# CITY OF ALBUQUERQUE

June 6, 2005

**Re: Popeye's Chicken, Coors Road and Seven Bar Loop NW, Site  
Development Plan**  
**Engineer's Stamp dated 5-18-05 (B14-D10)**

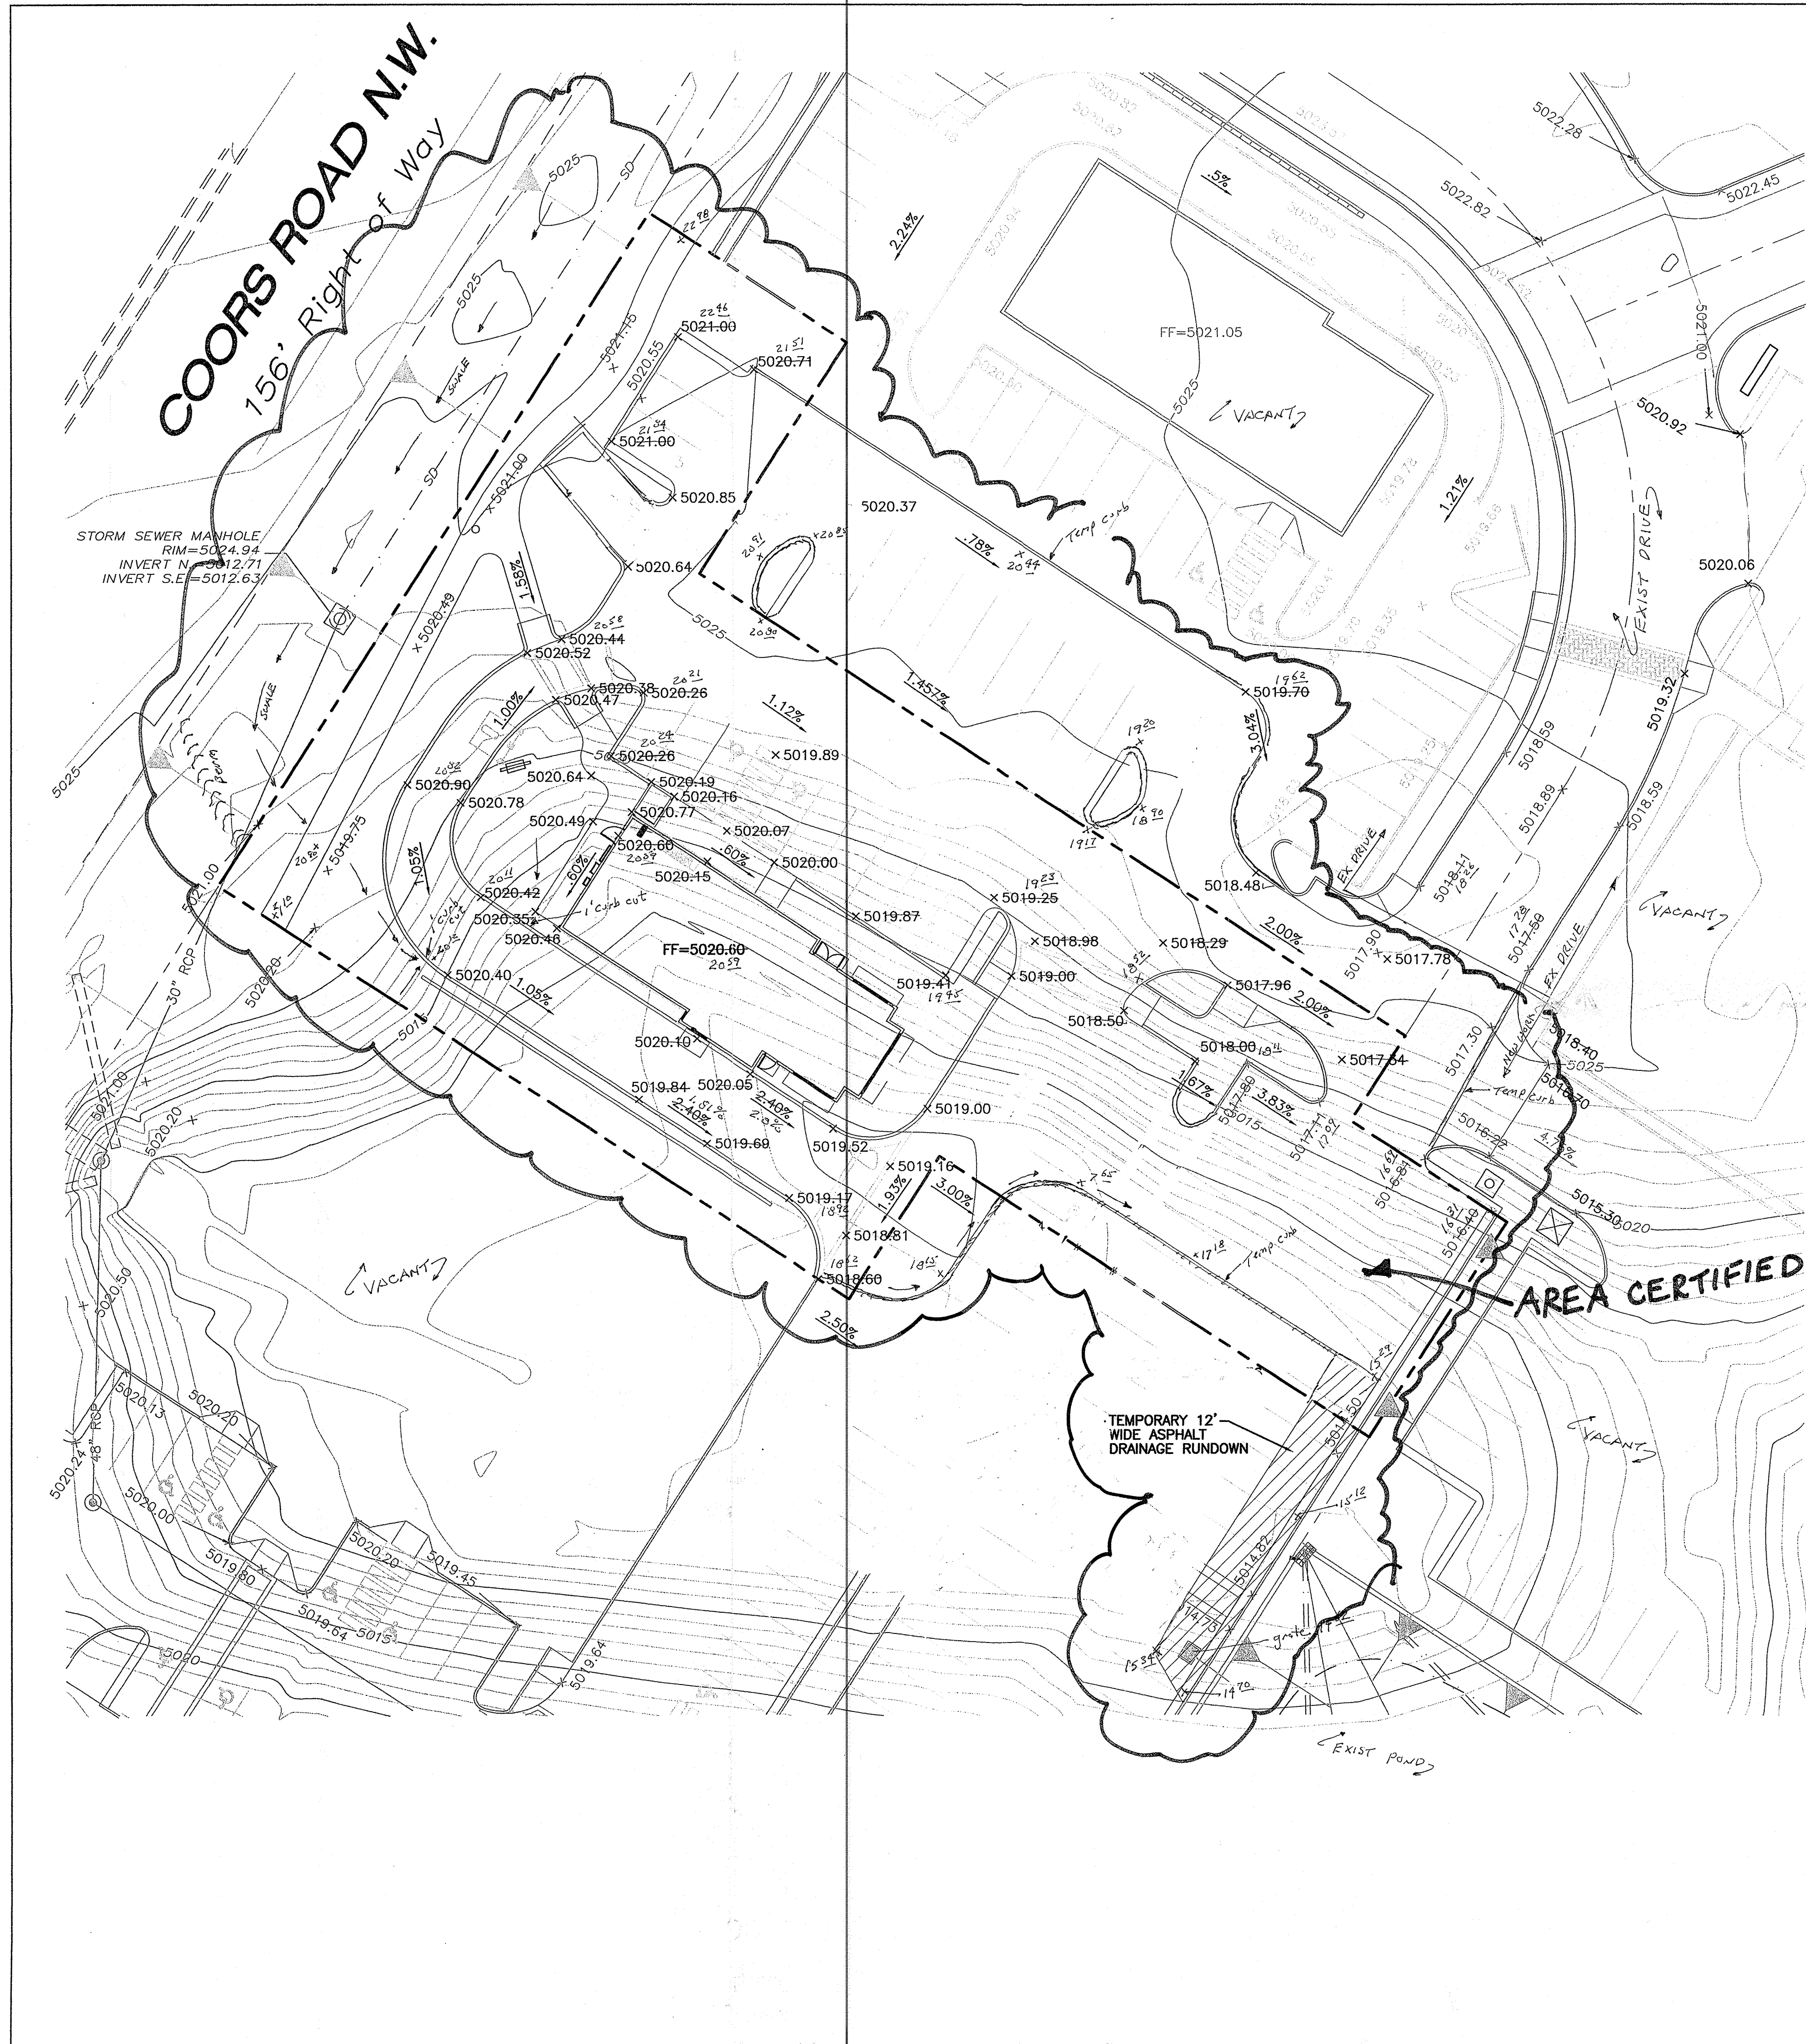
1. Provide a copy of the as-builts for this area.
2. Is the pond completed and approved?
3. How will the flow reach the pond? Please note that we will require a hard-lined route to the pond from the proposed site.
